Ribble Valley Borough Council
Council Offices
Church Walk,
Clitheroe
Lancashire
BB7 2RA

Phone: [REDACTED]
Email: [REDACTED]
Your ref: 3/2025/0147
Our ref: 3/2025/0147/HDC/KW
Date: 04 August 2025

Location: Peel Street Business Estate Peel Street Clitheroe BB7 1RA
Proposal: Proposed demolition of existing buildings and erection of six 2-bed and one three-bed apartment building together with a two storey business centre and associated parking and bin store.
Grid Ref: 374509 441572

Swept Path Analysis and Visibility Splay Drawing

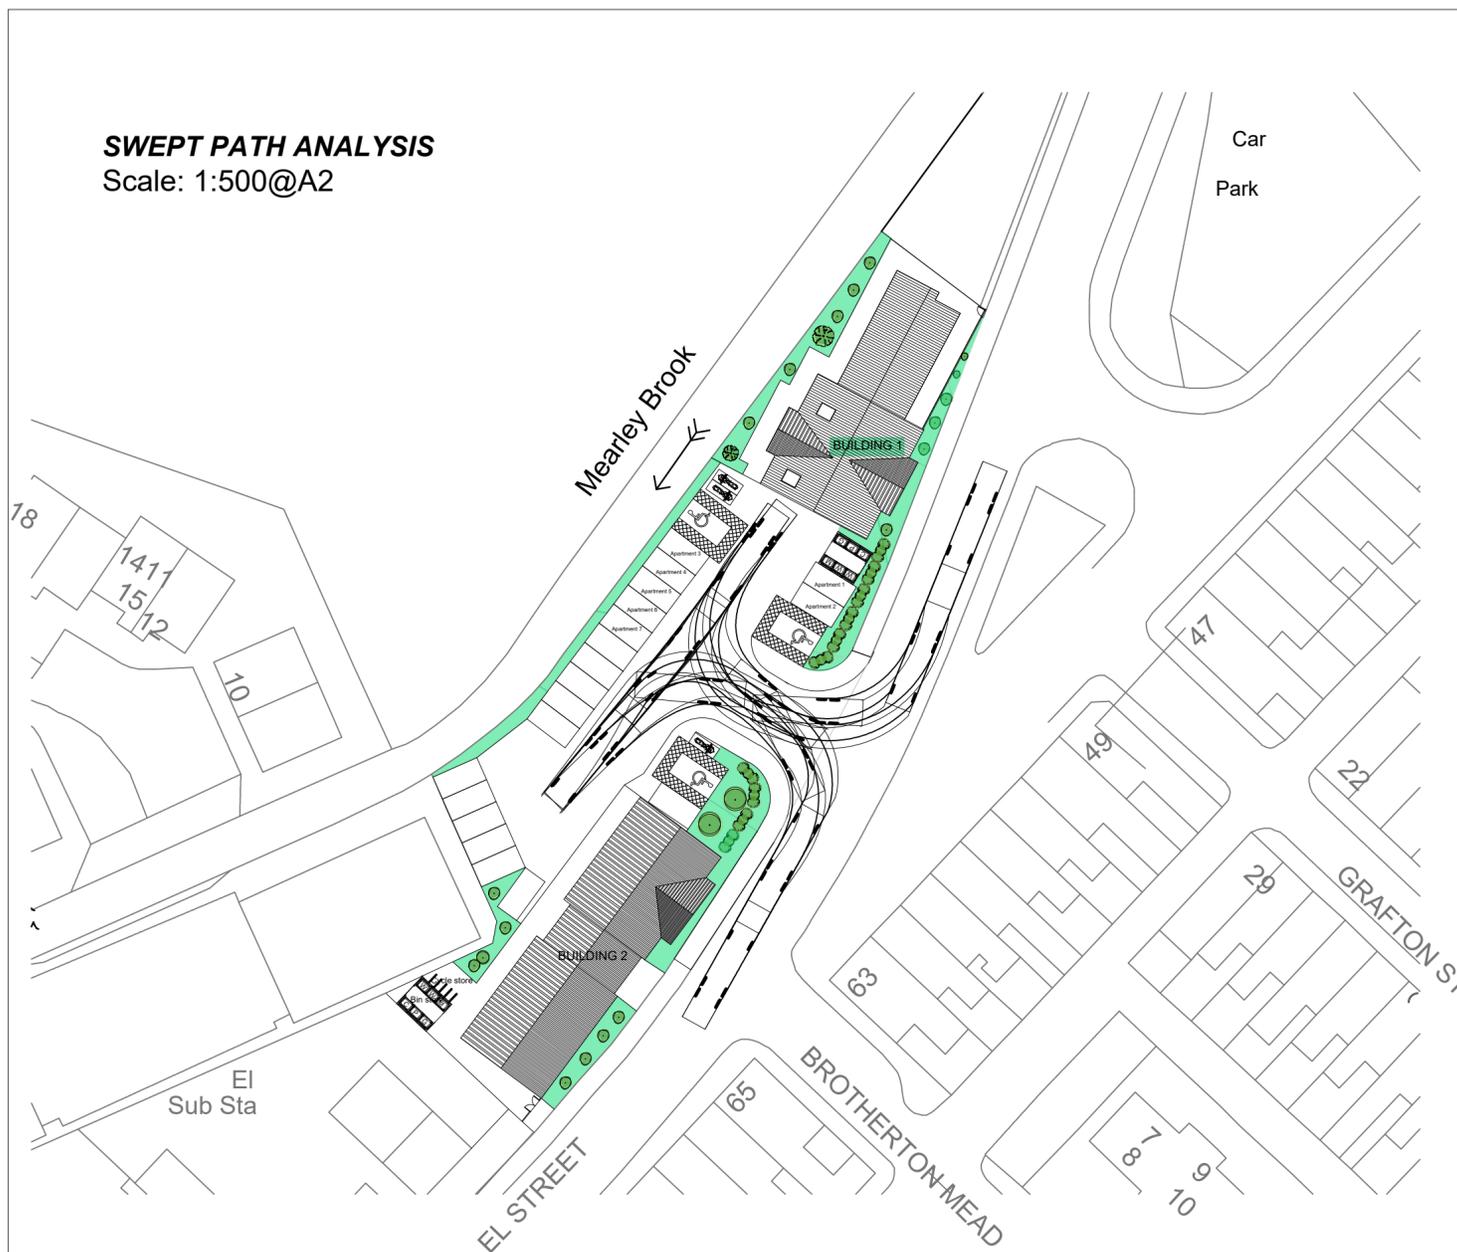
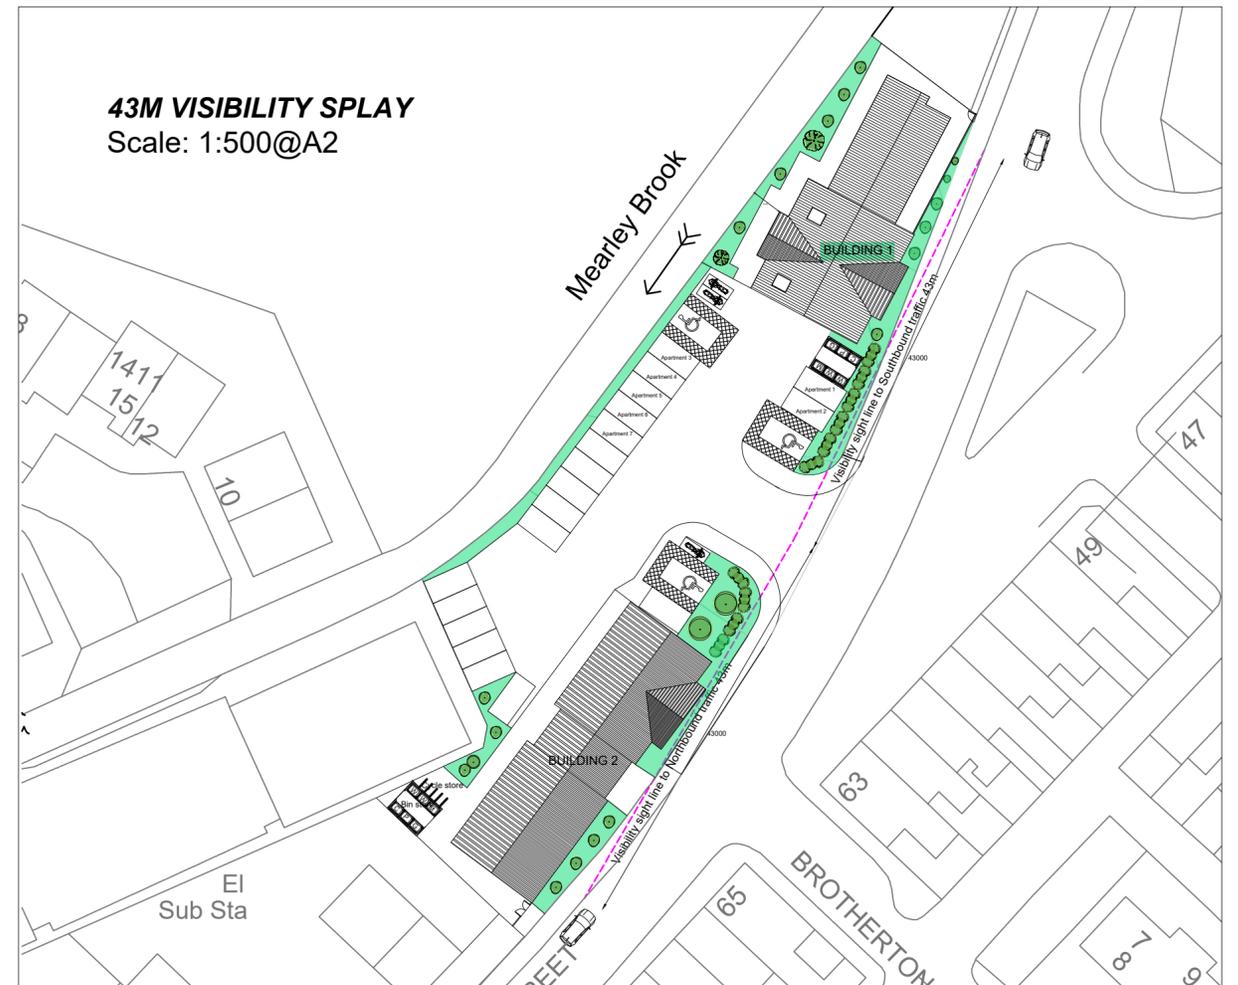
However, the applicant has now provided a swept path analysis drawing which shows the swept path of a large rigid truck using the access, the LHA will require the access to be extended by a further 0.5m. This is because, as a large rigid truck is entering the site, as shown on the swept path drawing, it meets the kerb line of the footway. Therefore, the LHA are concerned that should a pedestrian be using the footway at the same time as a rigid truck entering the site, a potential conflict could occur, as well as concerns about potential damage to the kerb line. As a result, the LHA require the access width to be extended to prevent this conflict and any damage occurring to the footway.

**Swept Path Analysis and Visibility
Splay Drawing**

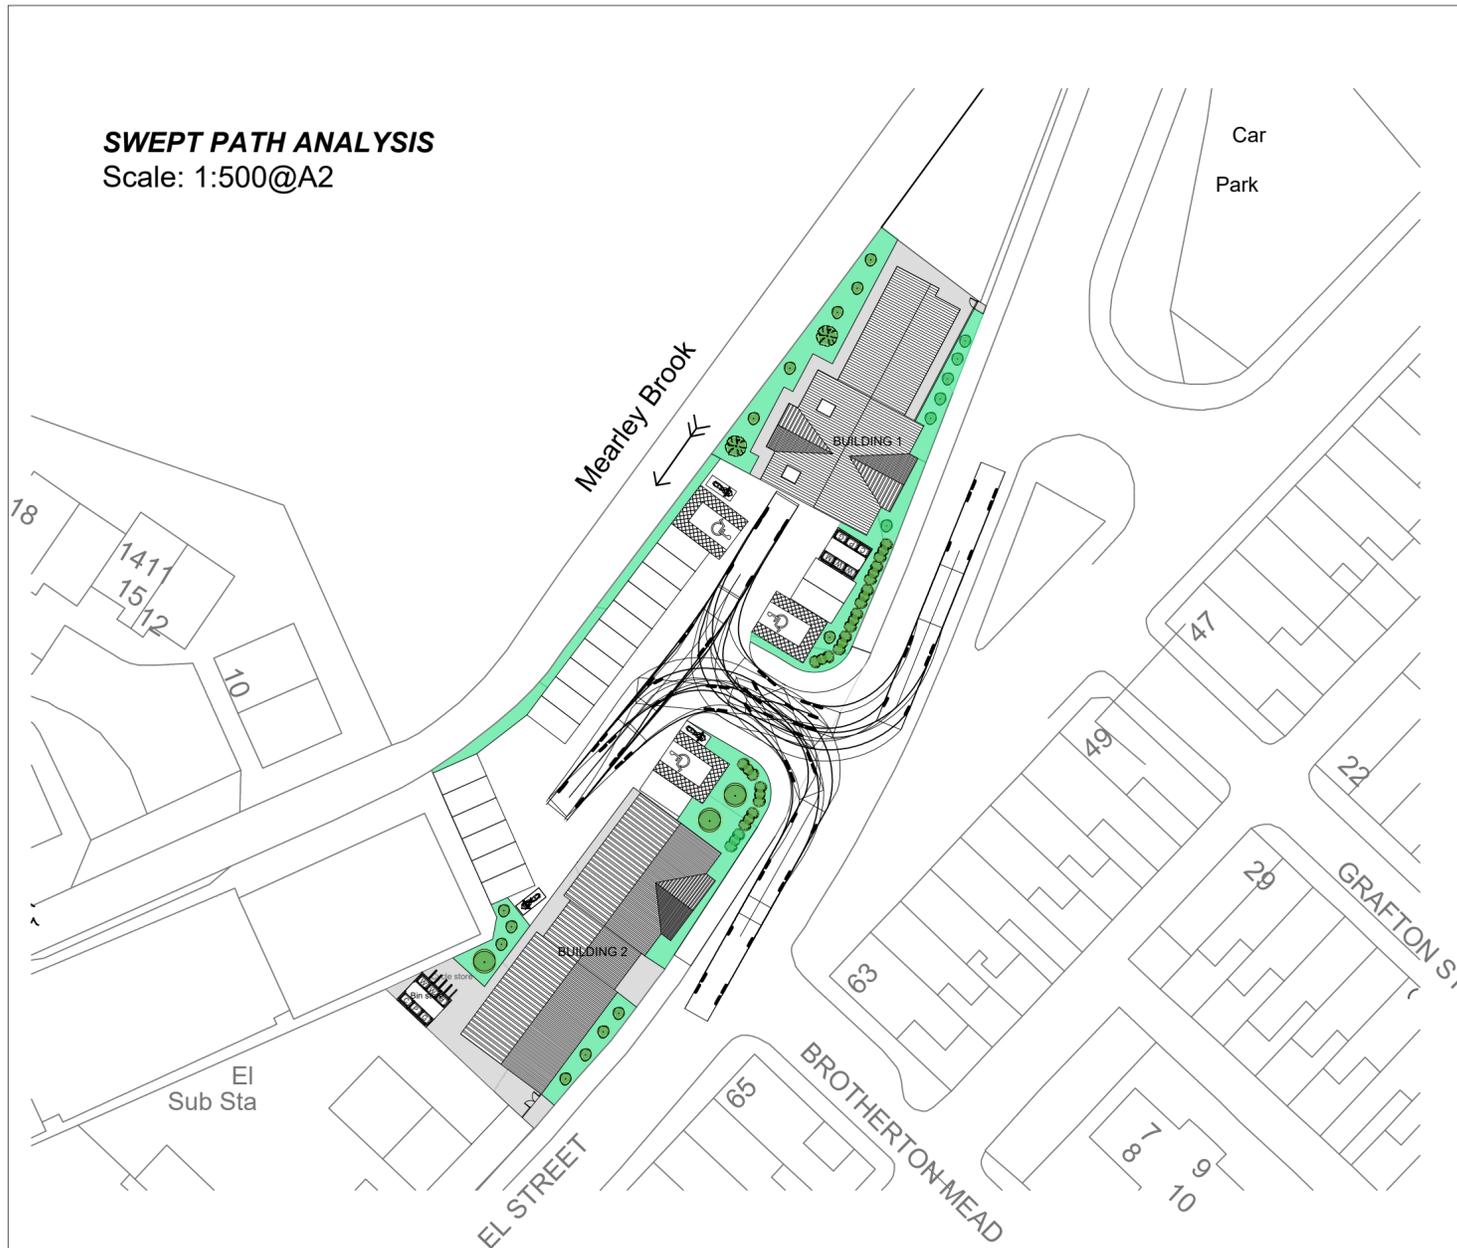
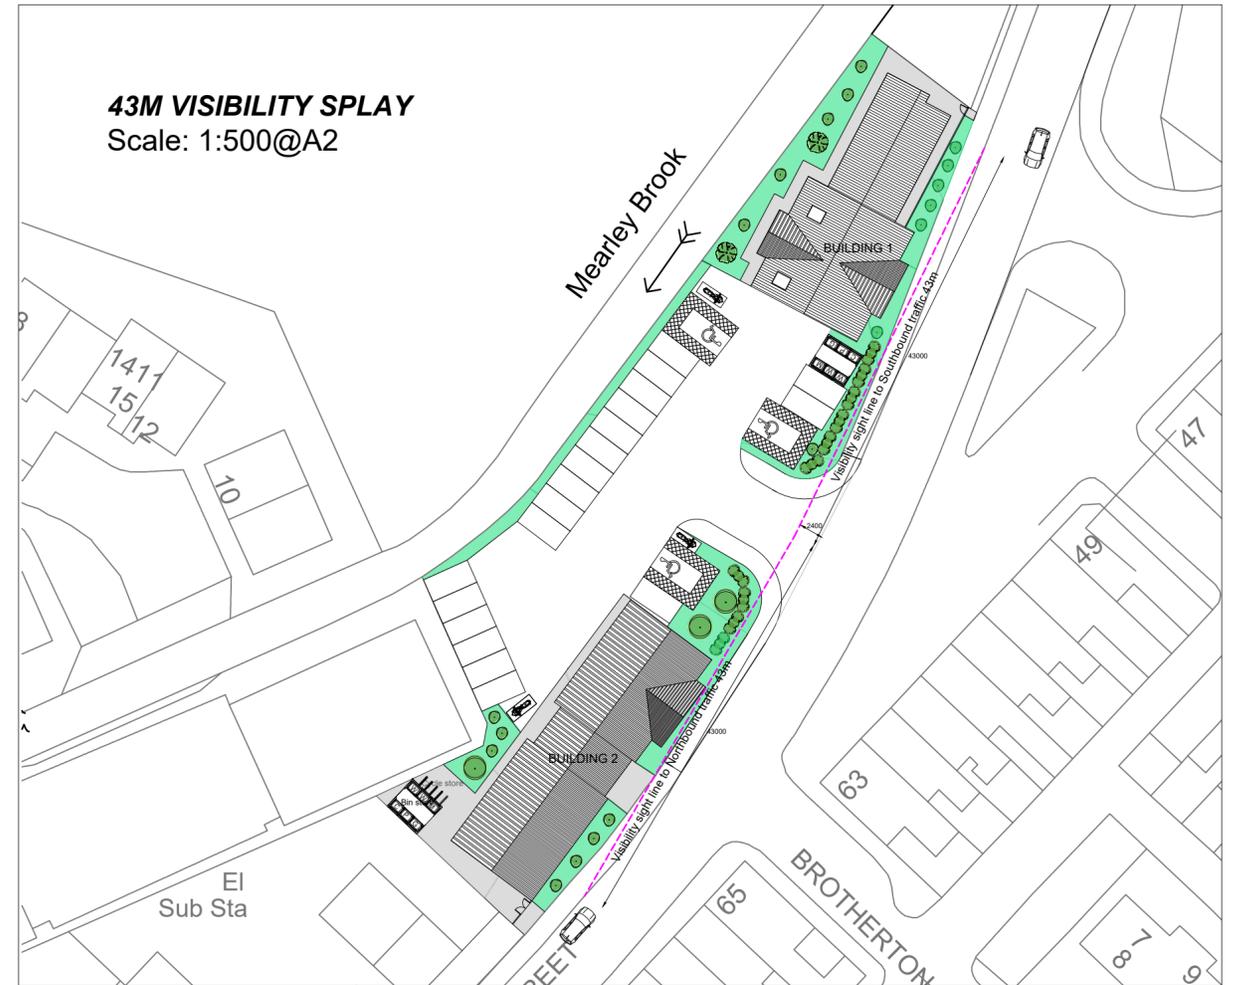
The applicant has also included a vehicular visibility splay drawing. This shows that the required vehicular visibility splays of 2.4m x 43m can be achieved in both directions and is therefore acceptable.

In conclusion, the applicant has now provided further drawings which show an acceptable visibility splay. A swept path analysis drawing has also been provided which shows the swept path of a large rigid truck using the access, the LHA will require the access to be extended by a further 0.5m to address conflict with the proposed access kerb line and footway provisions. Further attention is also still required to ensure the sites internal footway provisions are compliant with inclusive mobility. The LHA has also requested a slight amendment to the parking provision allocation; this should be clearly marked on an amended site plan.
